Ribble Valley Borough Council
Council Offices
Church Walk,
Clitheroe
Lancashire
BB7 2RA

Phone: 0300 123 6780
Email: developeras@lancashire.gov.uk
Your ref: 3/2025/0518
Our ref: 3/2025/0518/HDC/KW
Date: 02 October 2025

Location: The Bungalow Simonstone Lane Simonstone BB12 7NU
Proposal: Proposed first floor extensions and alterations.
Grid Ref: 377535 434134

SHEET: Proposed Site Plan

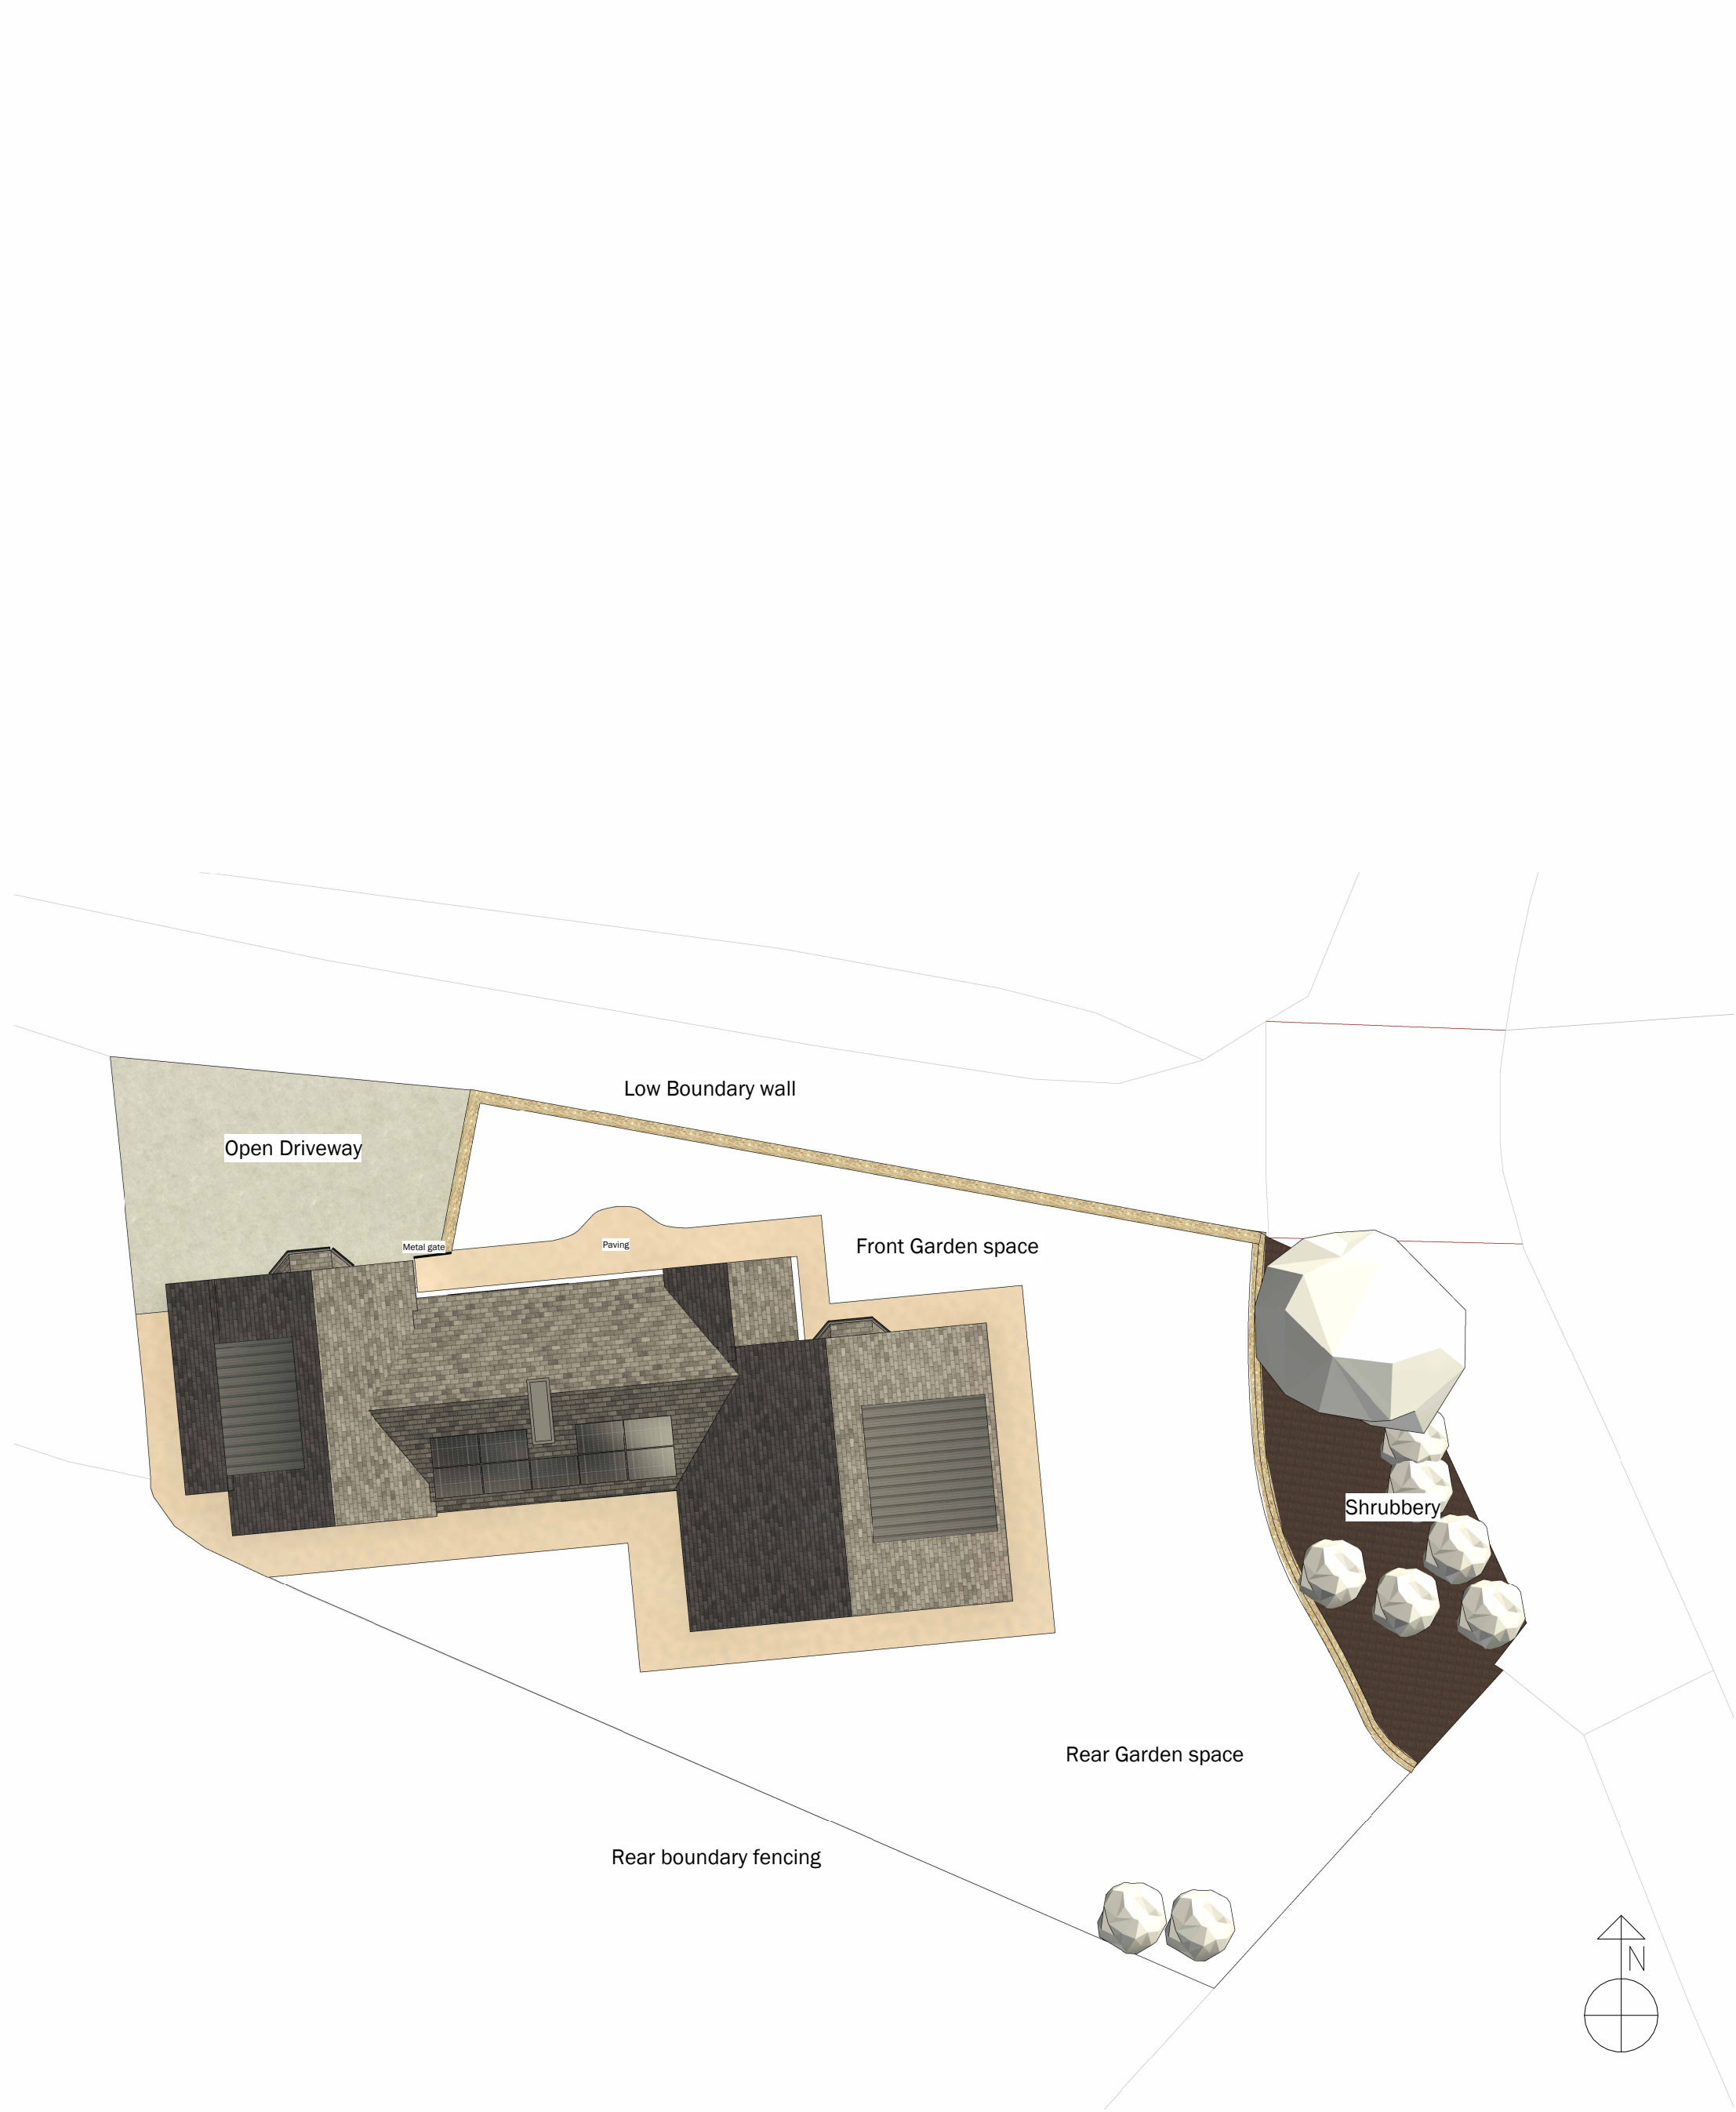
The LHA have reviewed PGB drawing number 003 titled "Proposed Site Plan" and are aware that the dwelling complies with the LHAs parking standards as defined in the Joint Lancashire Structure Plan.

of the garage door (600mm) and room to stand in front of the car and open/close the garage door (600mm). The proposed alterations to the garage meet the recommended minimum internal dimensions to support off-street parking provisions, and the existing driveway will be unaltered, supporting additional off-street parking spaces.
